From: Martyn White
Sent: 31 August 2018 11:23
To: Planning.Responses
Subject: FP/165/18/HH

FP/165/18/HH

The proposal is for a two storey extension to the property on the eastern elevation, with materials and colours to match existing.

Title
Elevations as Proposed

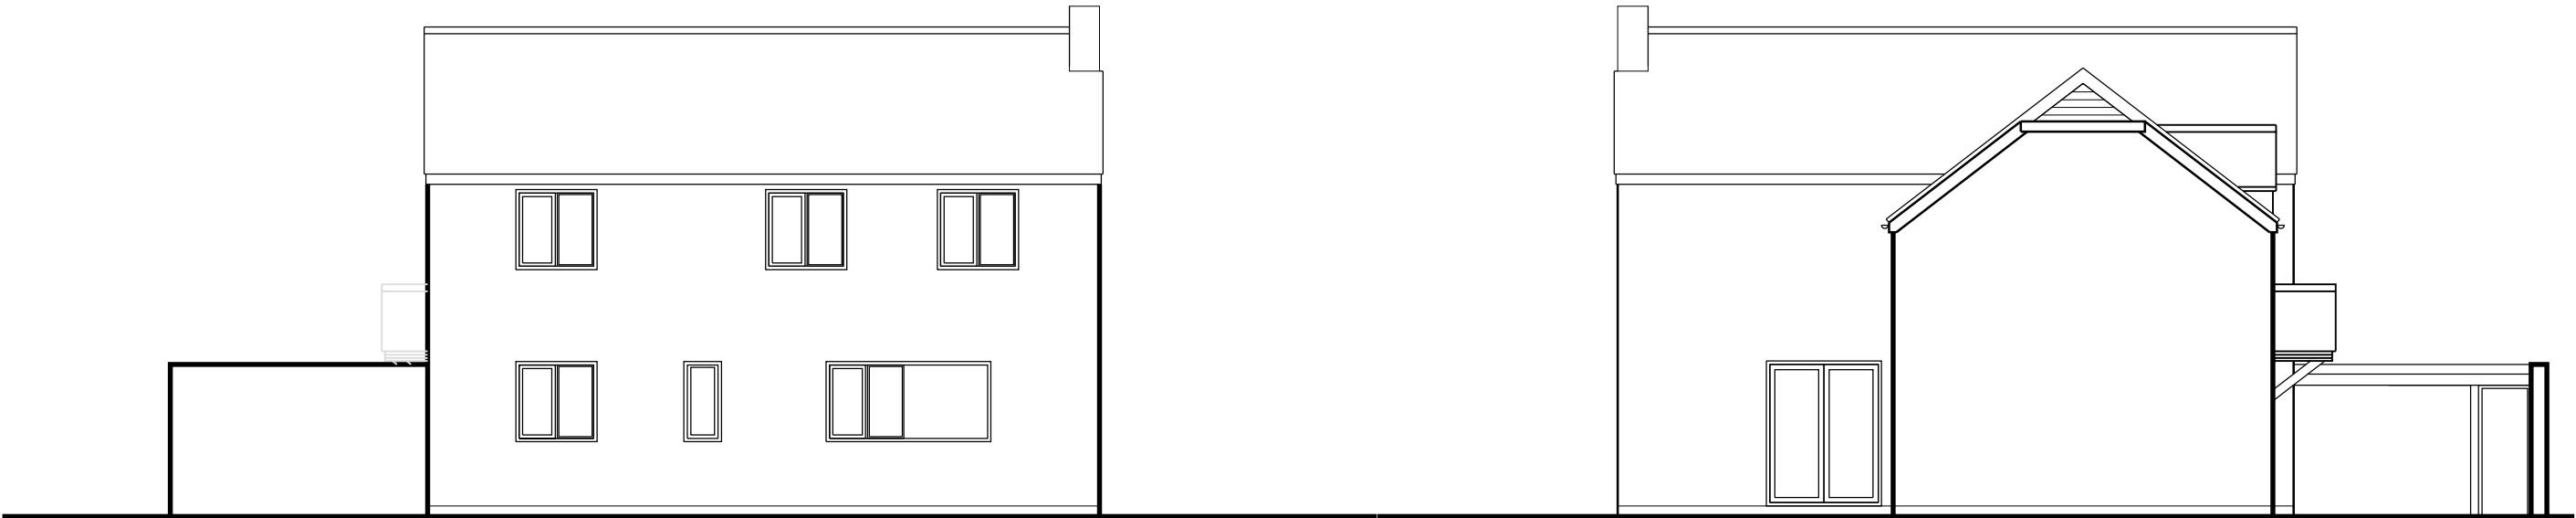
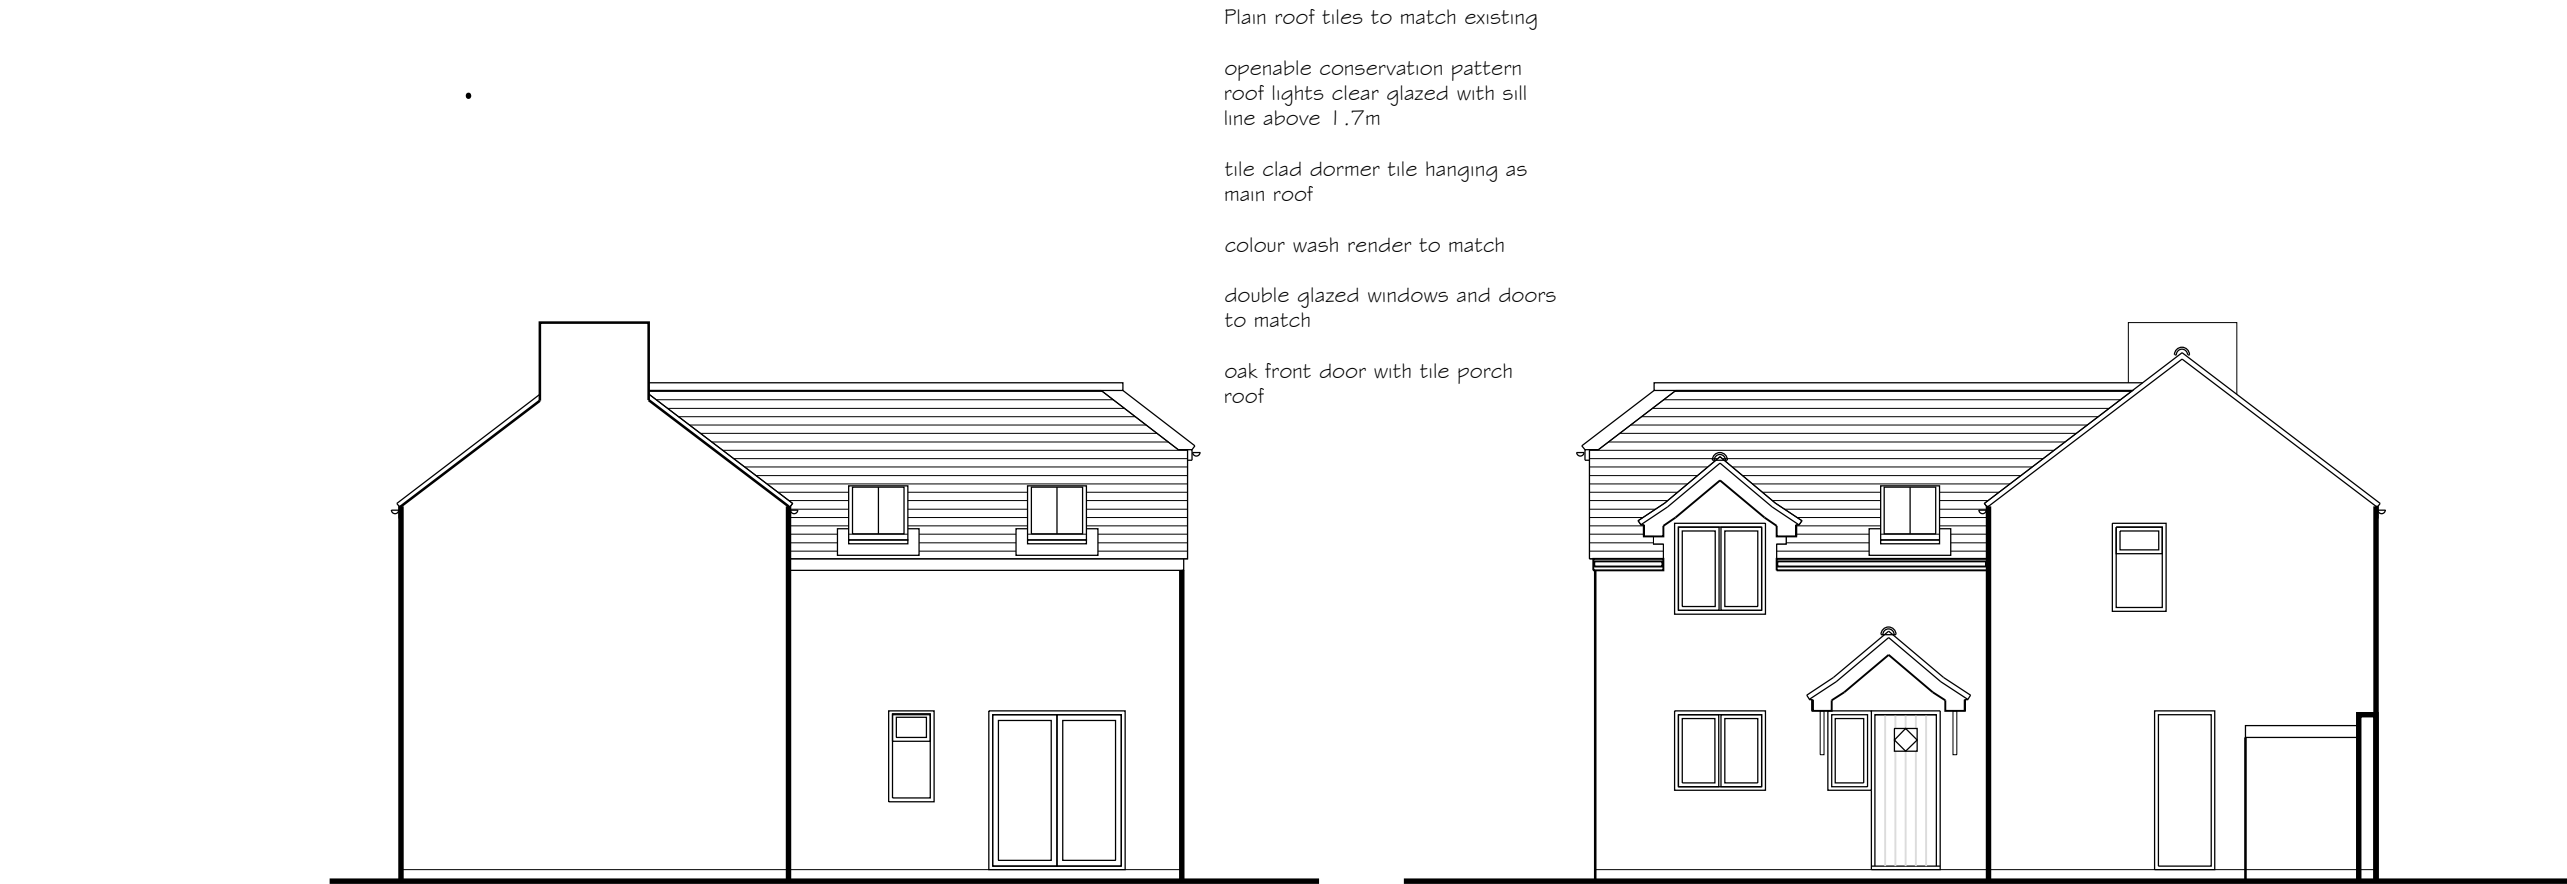
The proposal is such that the extension lies flush with the existing northern elevation. It therefore does not read as subservient structure. In addition, the location of the extension means that the porch sits forward of the extension and, due to its size, would dominate the elevation. It is considered that this does not allow the extension to be read as a later addition.

It is considered that the extension should be set back to some extent from the existing dwelling so that it can be read as a small-scale, subservient extension, which would reduce its impact on the street-scene. This would then allow for the impact of the porch to be lessened.

The front door also looks modern in character, and it is not clear if this would sit comfortably with the existing (traditional) building. Three rooflights are also included within the design, and due to the fact that one would be visible on the street-scene, should be of a conservation standard/appearance.
